Re: Objection to The Timberyards Rental Housing Project at multiple lots bound by Victoria Road, Sydenham Road, Farr Street and Mitchell Street, Marrickville – SSD-76927247

This objection has been prepared by Mecone Group (Mecone) on behalf of a landowner group in relation to SSD-76927247 for The Timberyards rental housing project, comprising built to rent housing (BTR), co-living housing, in-fill affordable housing, commercial premises and public and private recreation area at multiple lots bound by Victoria Road, Sydenham Road, Farr Street and Mitchell Street, Marrickville.

Drawing No.	Drawing Name
L-101	DEEP SOIL ZONING

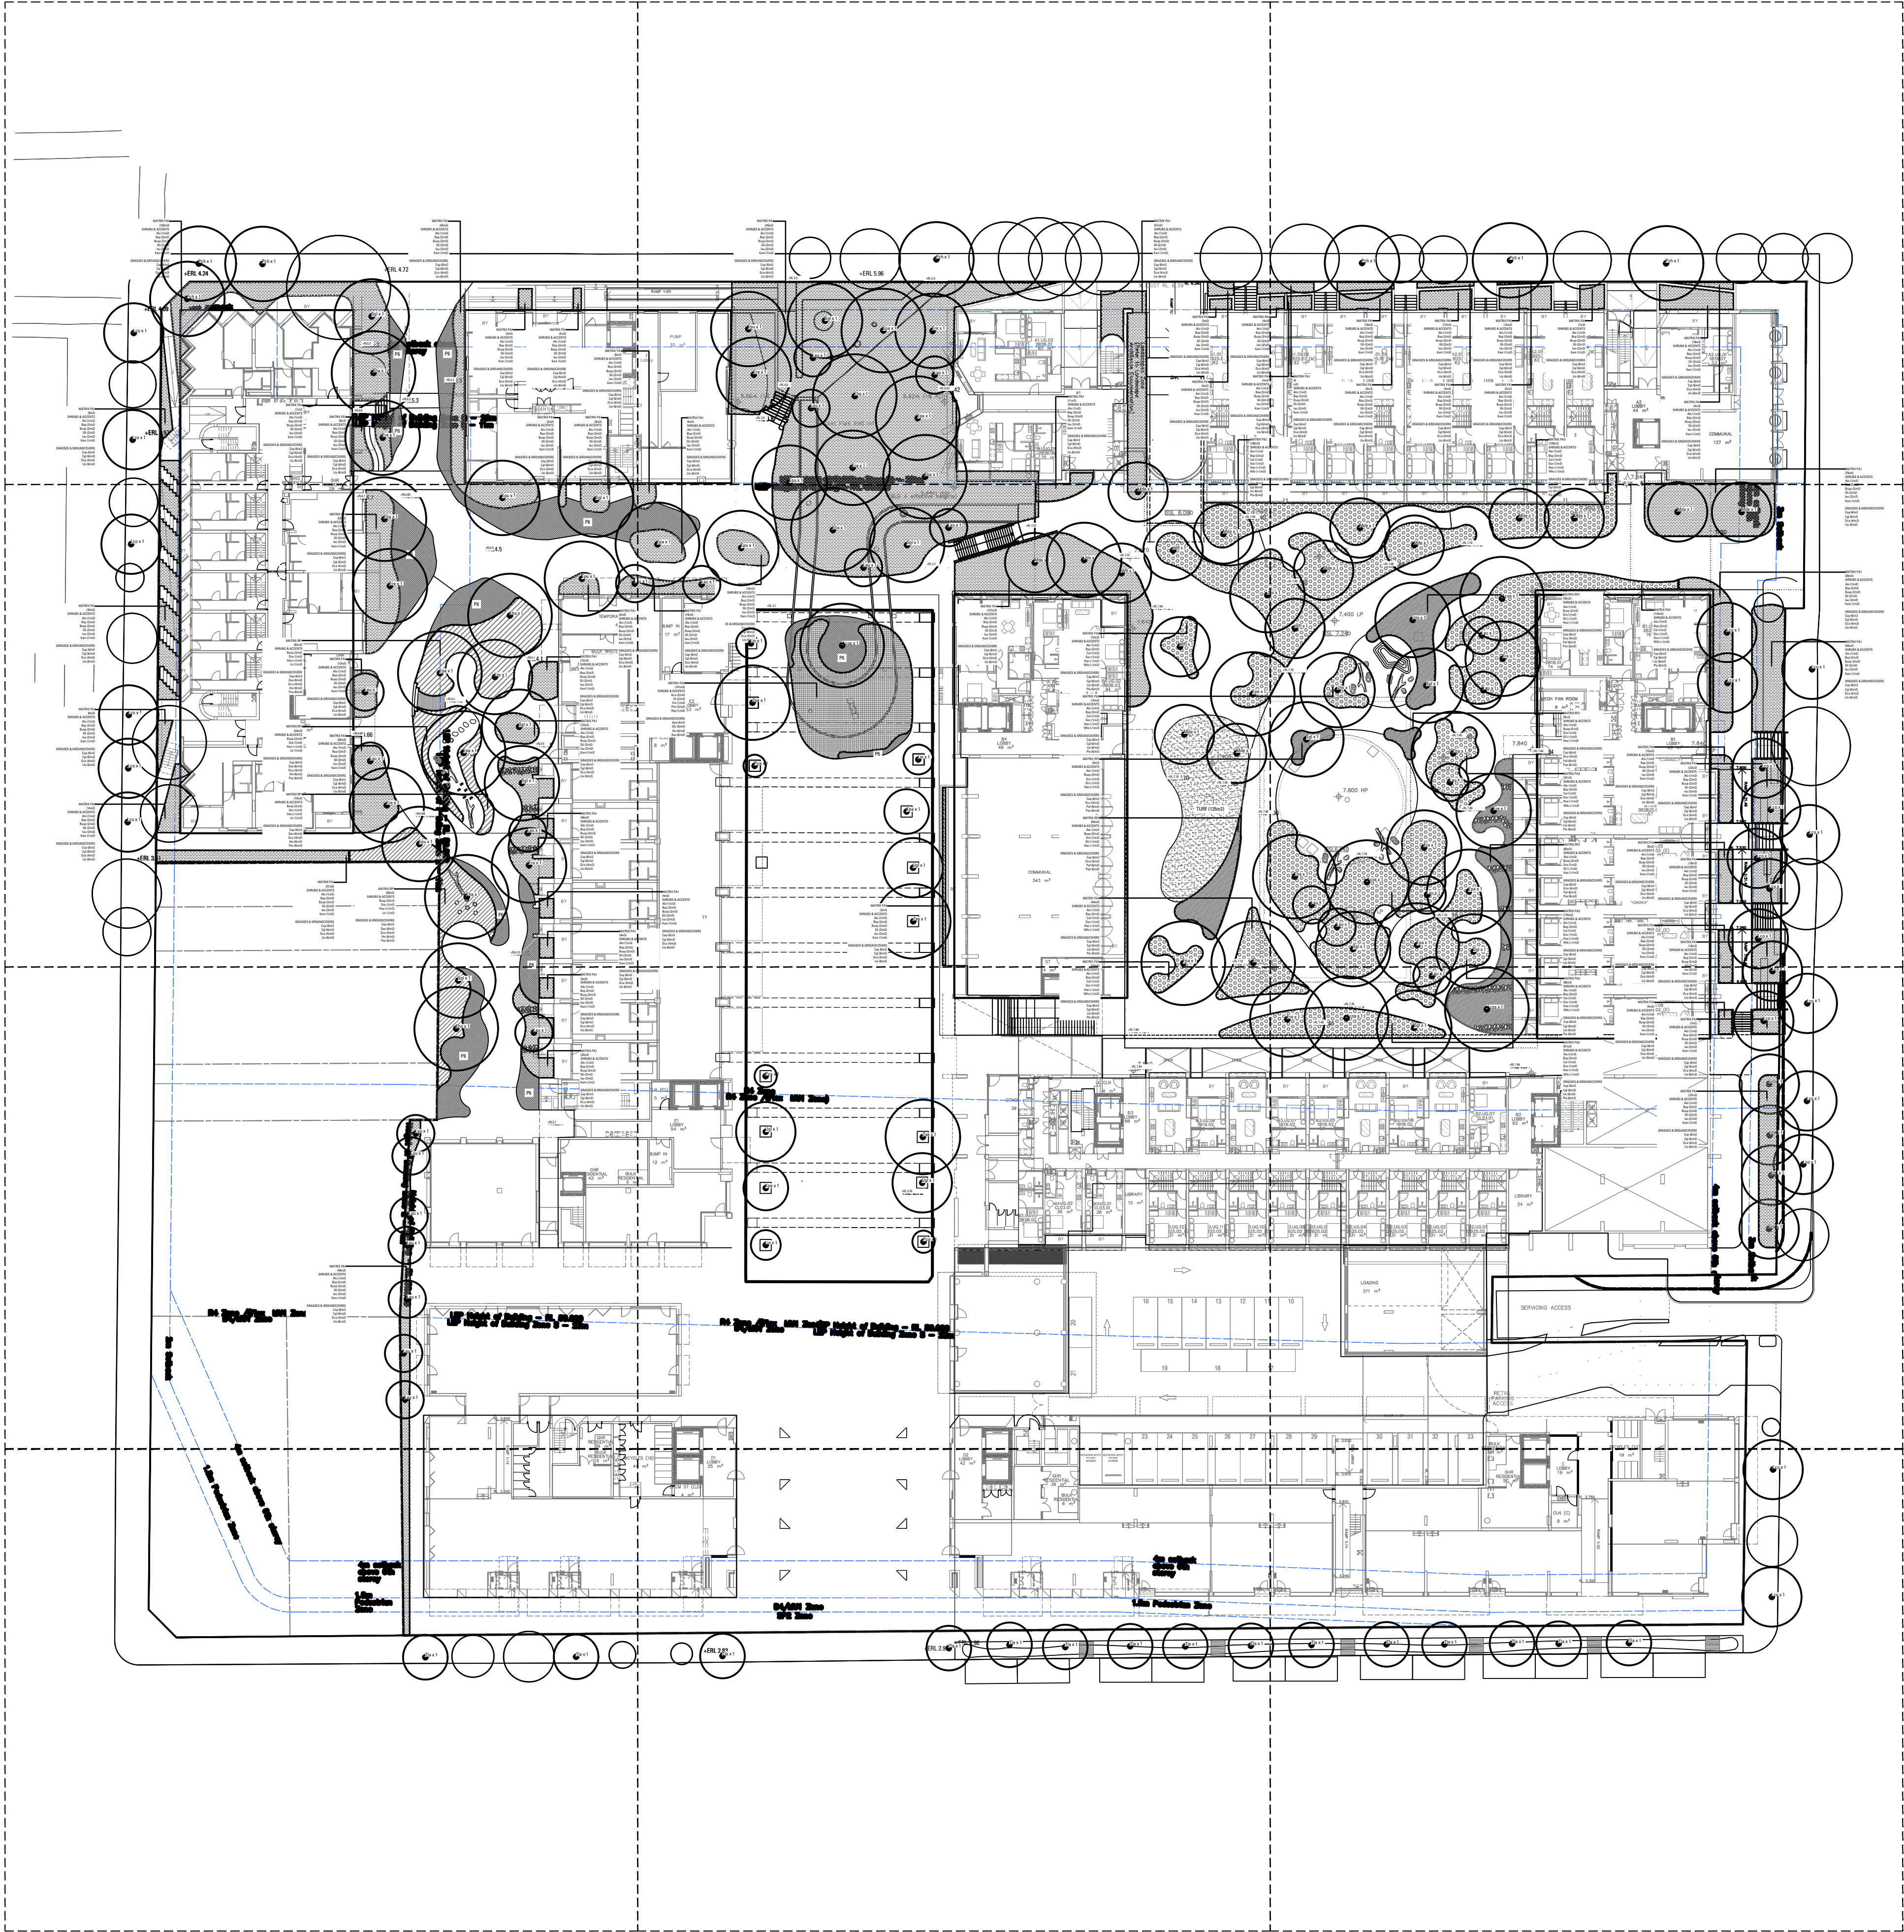
The design guidance of Objective 3E-1 in the ADG requires 15% of the site to be provided as deep soil over sites with an area of over 1,500m². While the EIS states a 10% deep soil zone is achieved, the proposed 14% deep soil zone total appears to rely heavily on areas that are fragmented or marginal (e.g. front setbacks and edges of internal roads), and not contiguous or functional for canopy trees.

Further, site coverage is excessive, and despite large communal zones at podium levels, the landscaped area at ground level is insufficient and does not achieve the intent of ADG Objective 3B-1.
